Application for a non-material amendment following a grant of planning permission.

The proposed development is an affordable housing mix development totalling 48 dwellings of mixed tenure local needs housing and open market housing including amenity land and associated works (approved by Appeal ref. APP/D0840/A/14/2228721, as amended by application ref: PA17/02923 on 27th February 2018)

## 6. Non-Material Amendment(s) Sought

GROUP 12 / BLOCK H (Units 24-25)

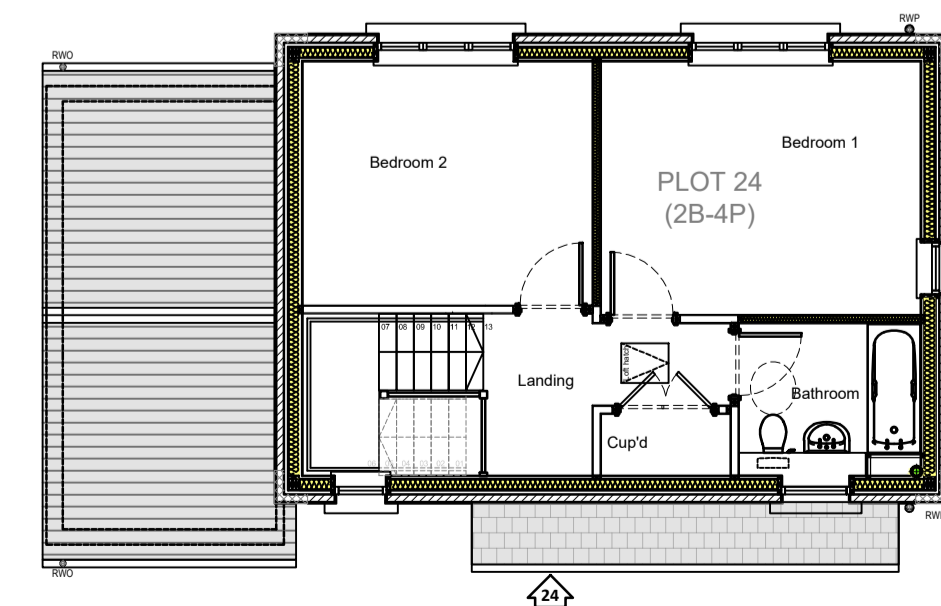
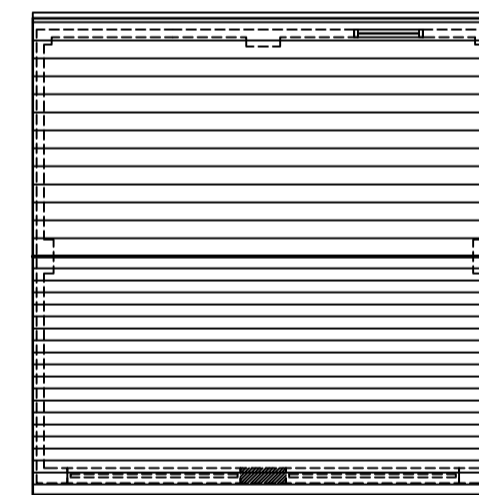
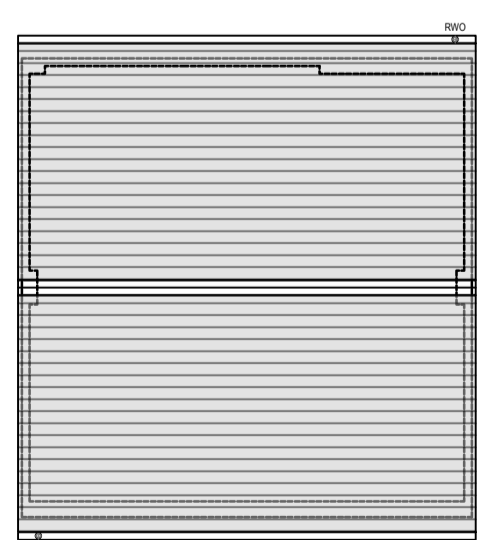
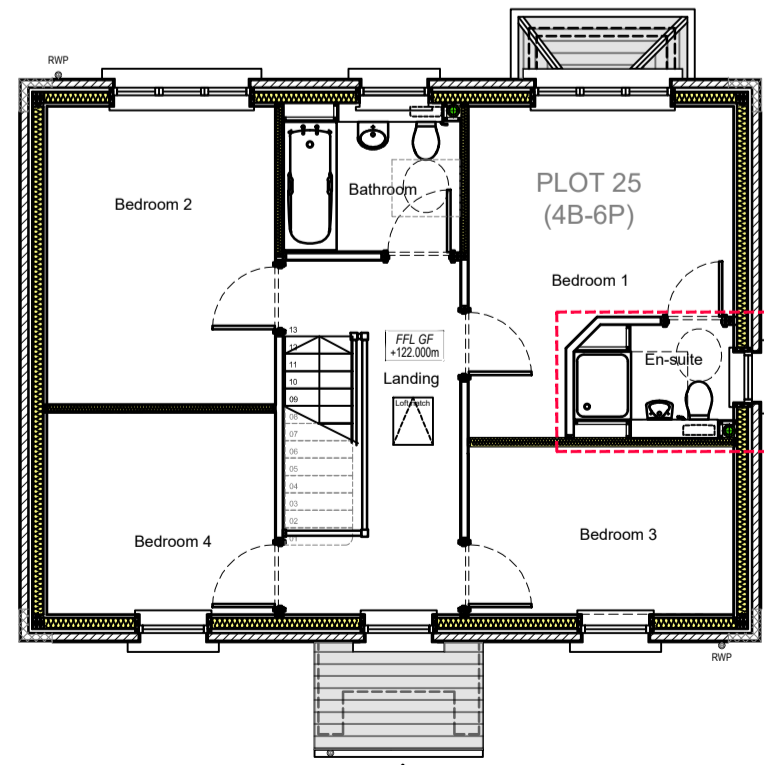
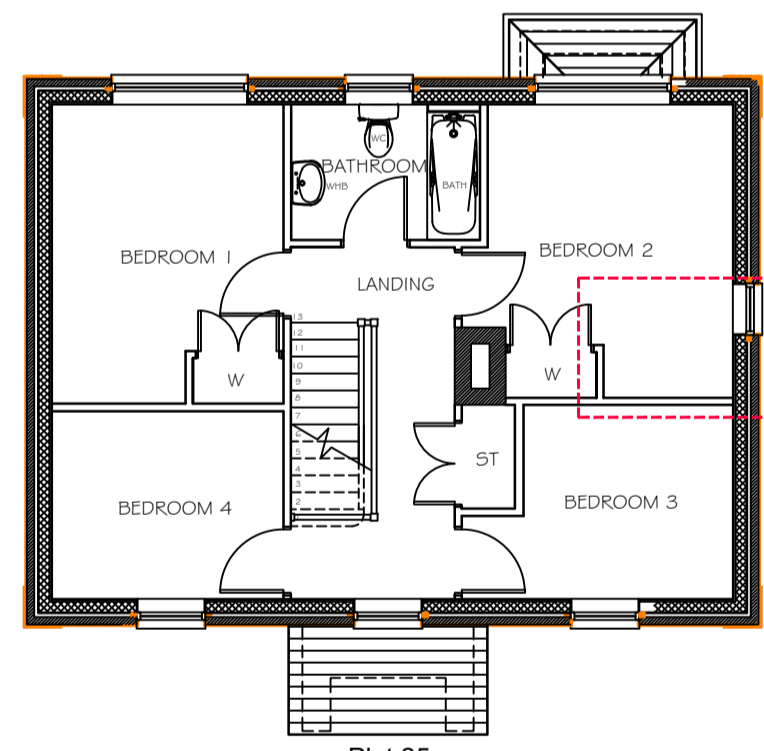
- minor internal modifications to downstairs bathroom and removal of storage cupboard to plots 6 and 7, 17-20, and minor changes to canopies of 17-20.
- chimney position inset from gable end on plots 22 and 23,
- provision of en-suite bathroom and obscure glazing to plots 26 and 27,
- minor changes to the canopy of plots 27 and 28,
- internal changes to partitions to plots 42 and 43 and plinth detailing,
- minor changes to the plinths and canopy of plots 28 and 29,
- updated materials legend for consistency (materials change already considered under.
